Planning & Urban Development Department

February 24, 2014

Project Name: **Shoreline Stabilization Project**
Project ID: 2014-008
Address: 29 Oaklawn Road, Peaks Island
CBL: 090 H 002001
Applicant: Stanley & Marsha Reich
Planner: Philip DiPierro

Drawing file: 1. Original Plans / C2.0 Site Layout Plan.pdf

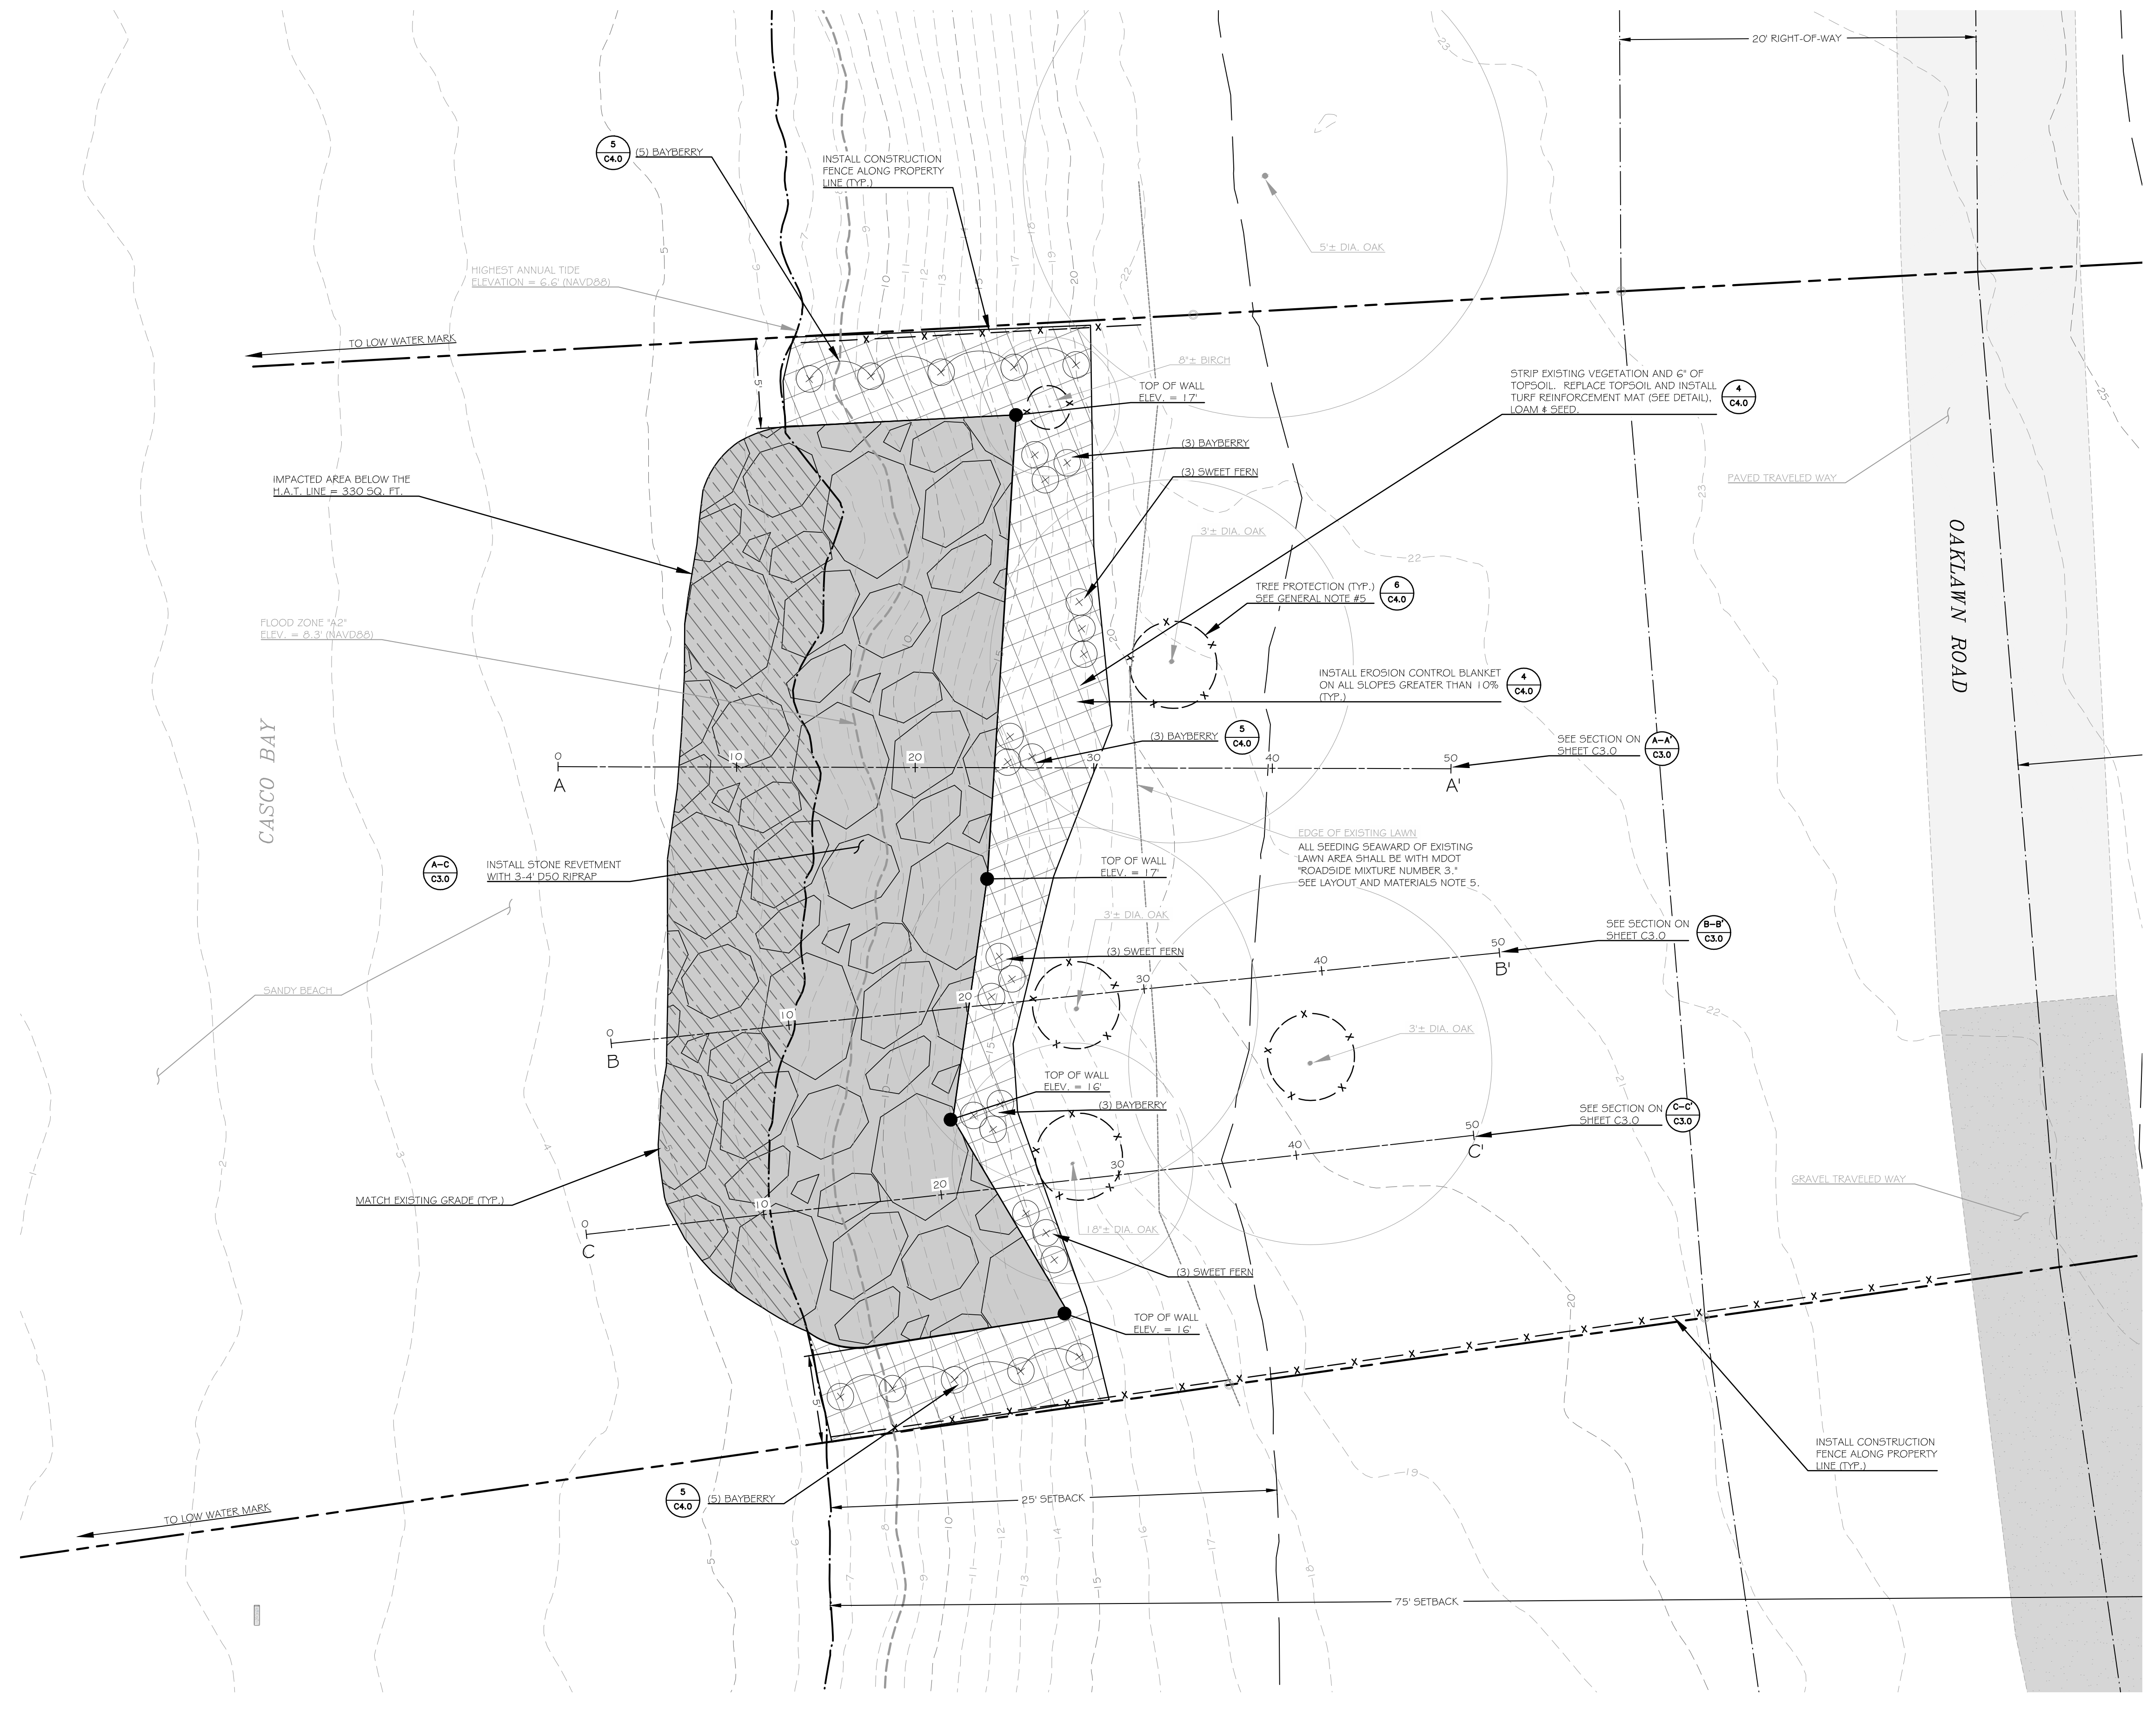
3. A revised landscape plan shall be submitted, for review and approval, to address the review comments of the City Arborist, Jeff Tarling.

They could use additional Bayberry plants... five per side minimum.
Perhaps a couple of groups of three up top. The plant cost
is pretty minimum and would be good to establish greenery
along the bank edge.
